Town & Country Planning Act 1990 (as amended)
Town & Country Planning (Development Management Procedure) (England) Order 2015
Application for Planning Permission for Works or Extension to a Dwelling

Development Single storey front extensions (garage and porch) and conversion of garage into habitable space.

Location 58 Golden Avenue East Preston

Proposed Site / Block plan
1:500 @ A3

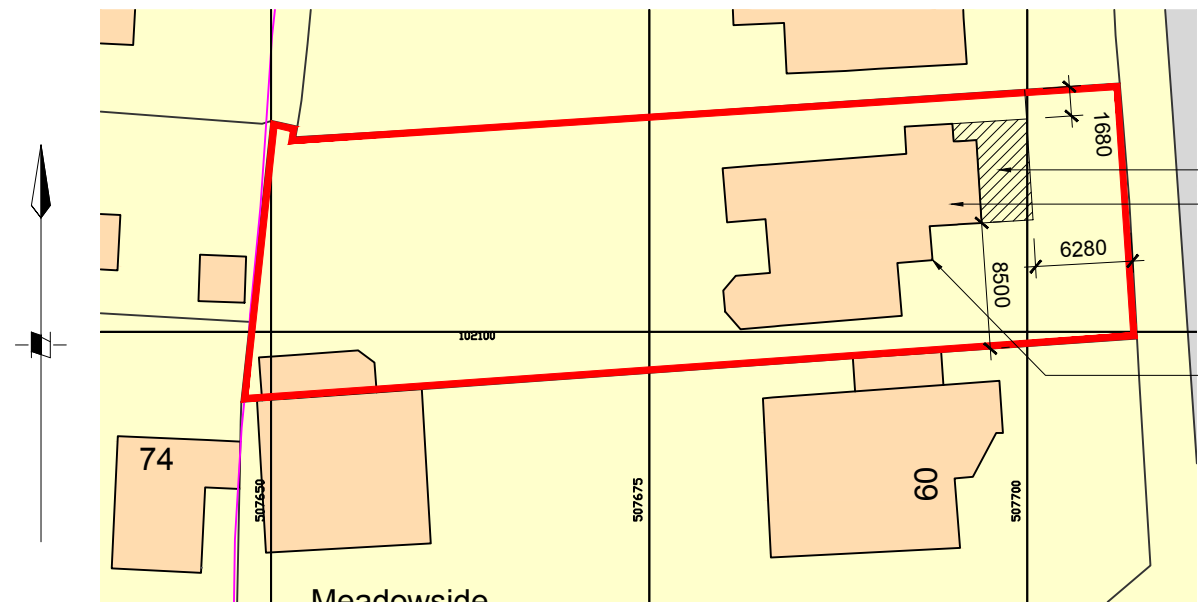
Block Plan

Please include a dimension to the other side boundary.
